Consultation Response from: KC Environmental Health (Pollution & Noise Control)

2025/92529 Land adjacent to 67 Chapelgate, Scholes, Holmfirth, HD9 1SX

Discharge of details reserved by conditions 6 (CEMP: Biodiversity), 10 (Phase II Intrusive Site Investigation Report), 11 (Remediation Strategy), 16 (retaining walls) on previous permission 2022/92406 for erection of 10 affordable dwellings, with access from Chapelgate and associated works, including resident play zone

Responding Date:
24th September 2025

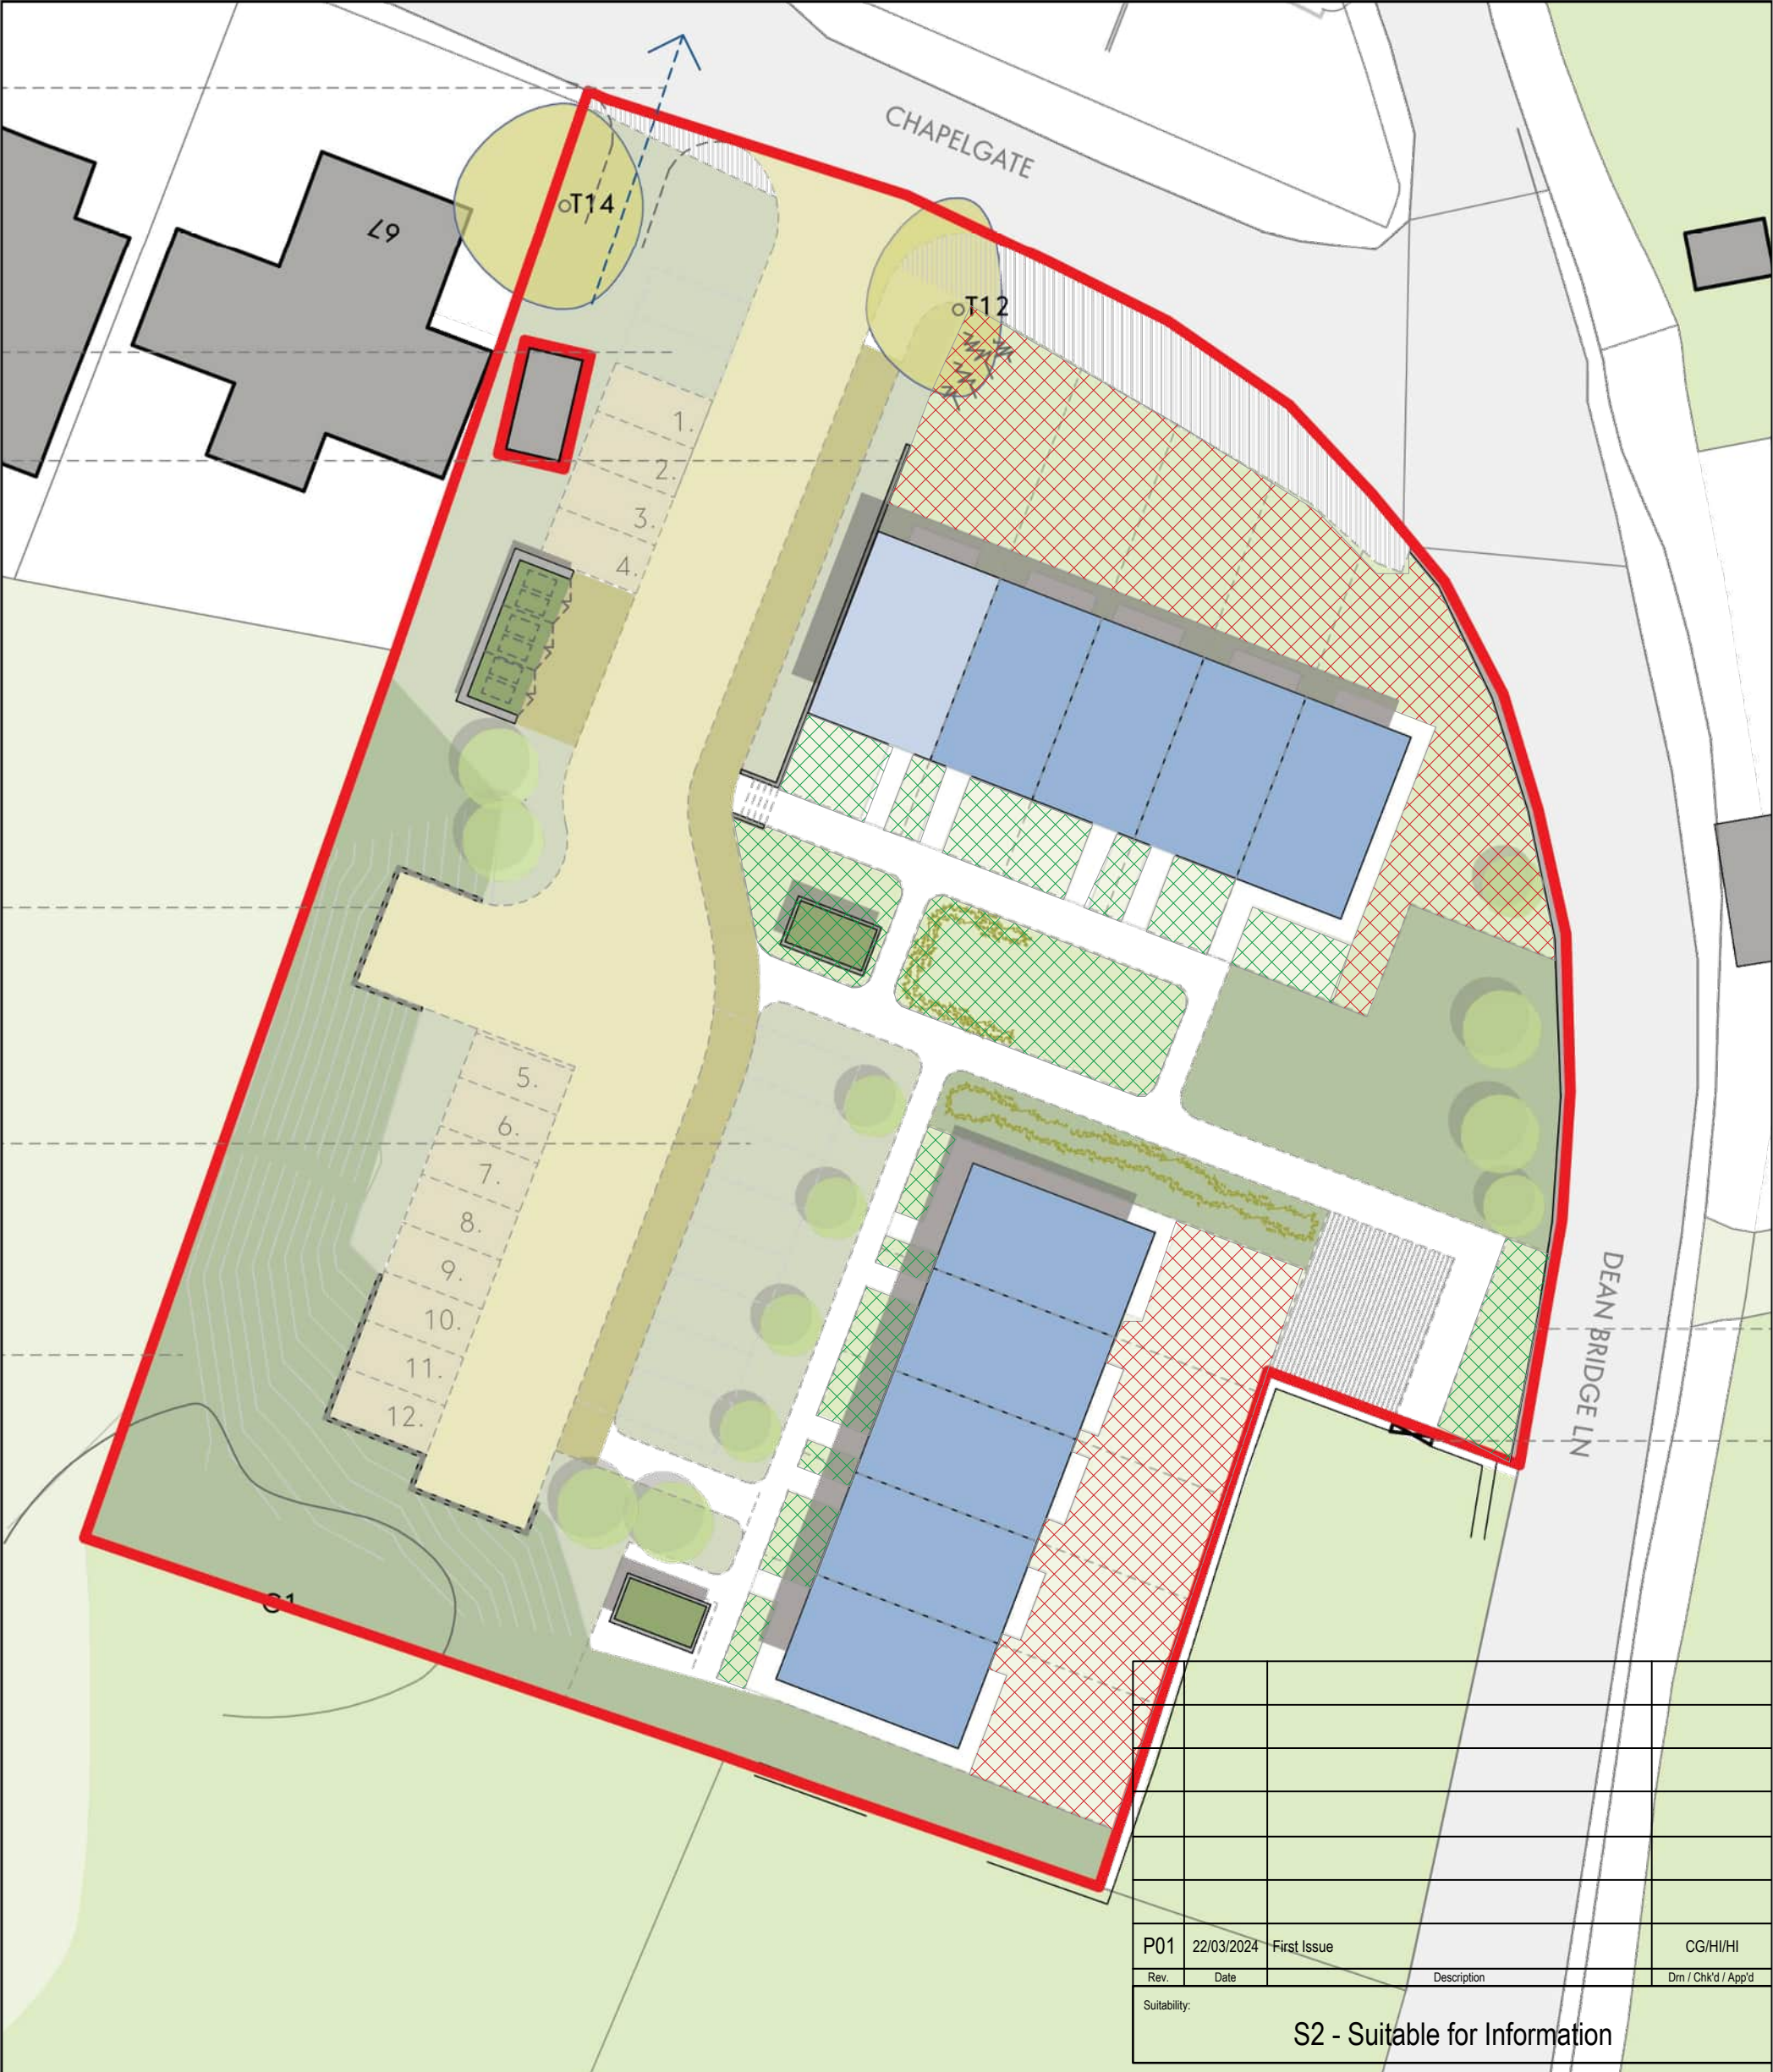
In relation to clean cover systems, we do not accept that front gardens can be distinguished from rear gardens for the purposes of adequate clean cover systems. We also wish to see commentary regarding what remediation, if any, will be carried out in the other wildlife/green areas shown on the site plan within the strategy, for example are these accessible by the public (fenced off), are these parts of the site subject to disturbance during works or remain untouched?

Due to the reasons given above we do not accept the Options Appraisal and Remediation Strategy by JNB Group, ref: B24367-JNP-XX-XX-RP-G-1003, dated April 2024, condition 11 remains.
